PLANNING AMENDMENT

Application No: HOS-0535-11 | A1

Description: Erection of one 10kw wind turbine

Amendment: Revised site plan (dwg. no. T004.001A)

Project:
Heron Orchard
9 Heron Gate
Hobbsdon Fen, Spalding, PE12 8SR
drawing title
PLANNING
Location Plan & Site Plan
client
Heron Orchard Holiday Park
date
17th May 2011
drawn
JMH
scale
1:1250 & 1:1000@A1
drawing no. rev
001 A
job no.
T004

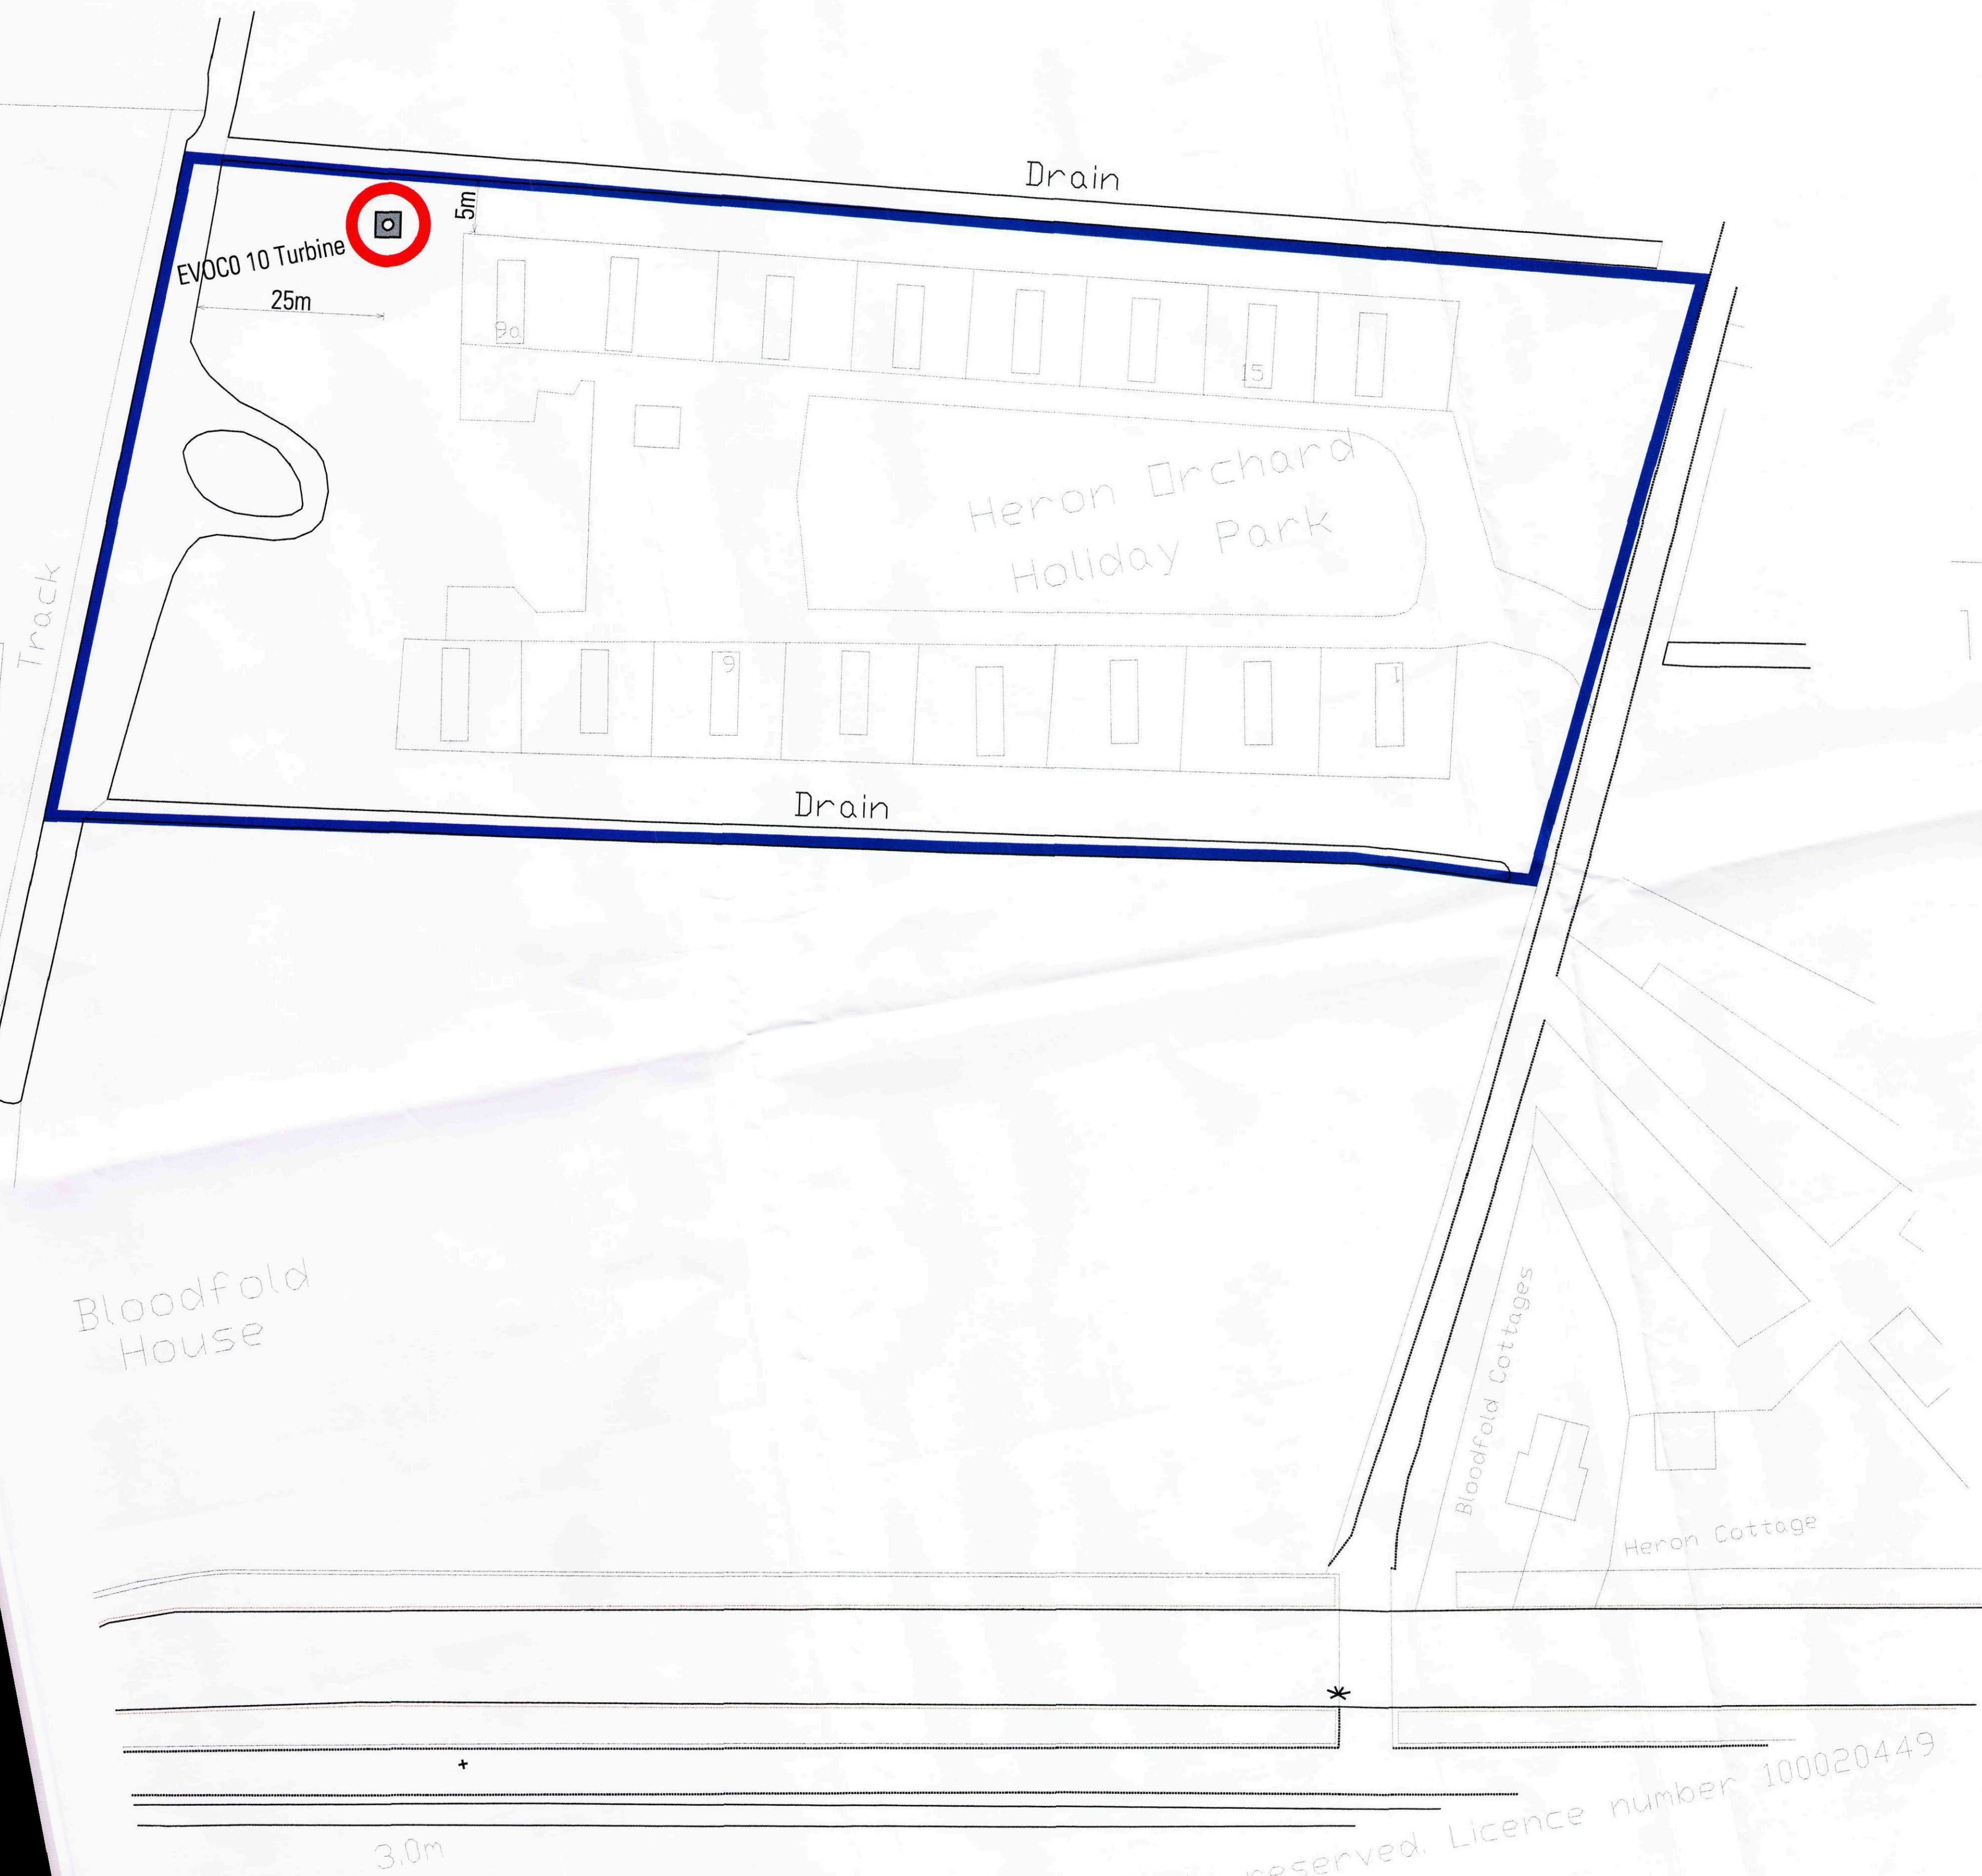
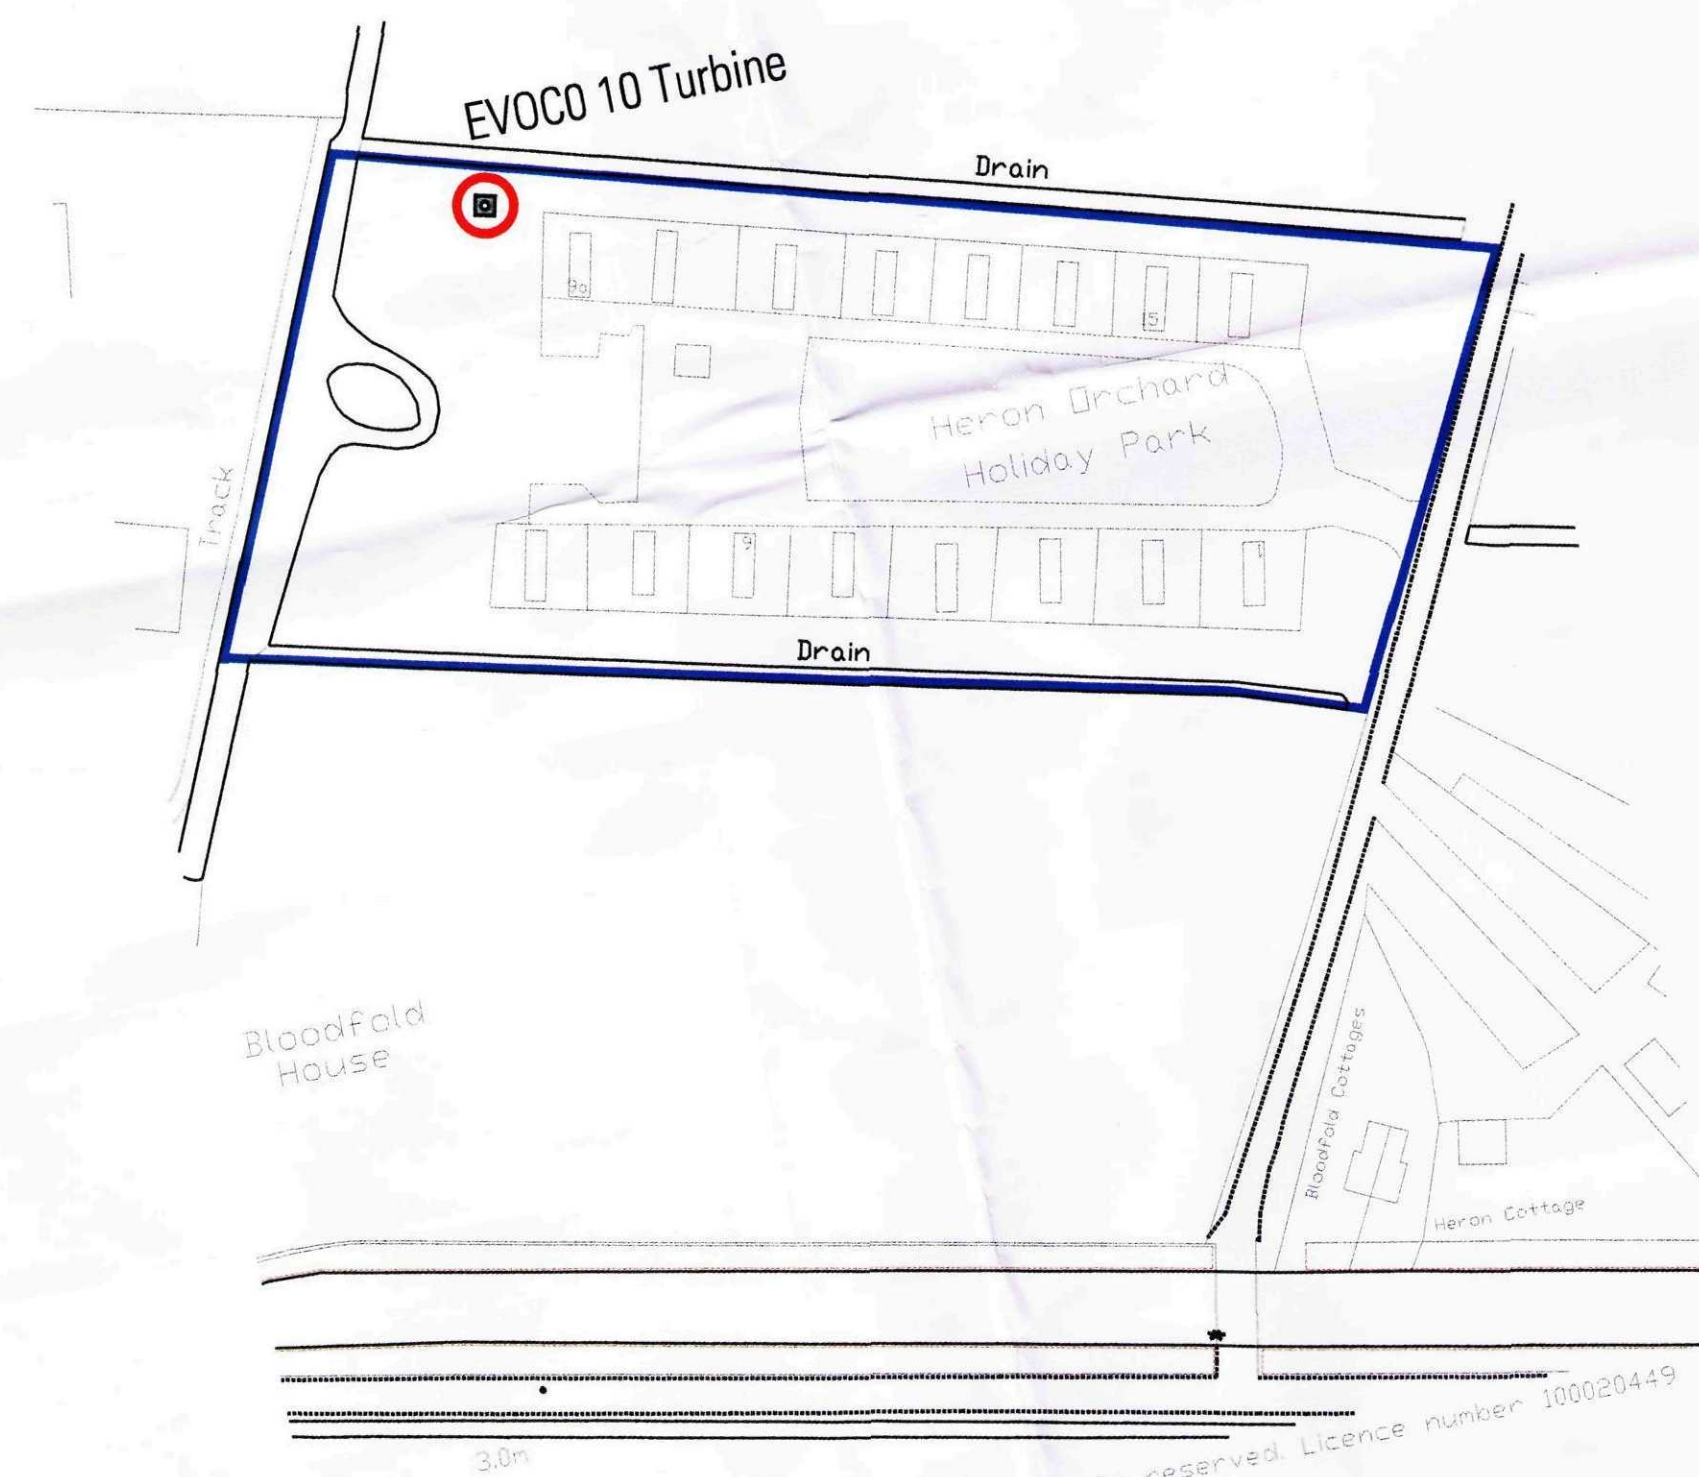
Attached revised site plan
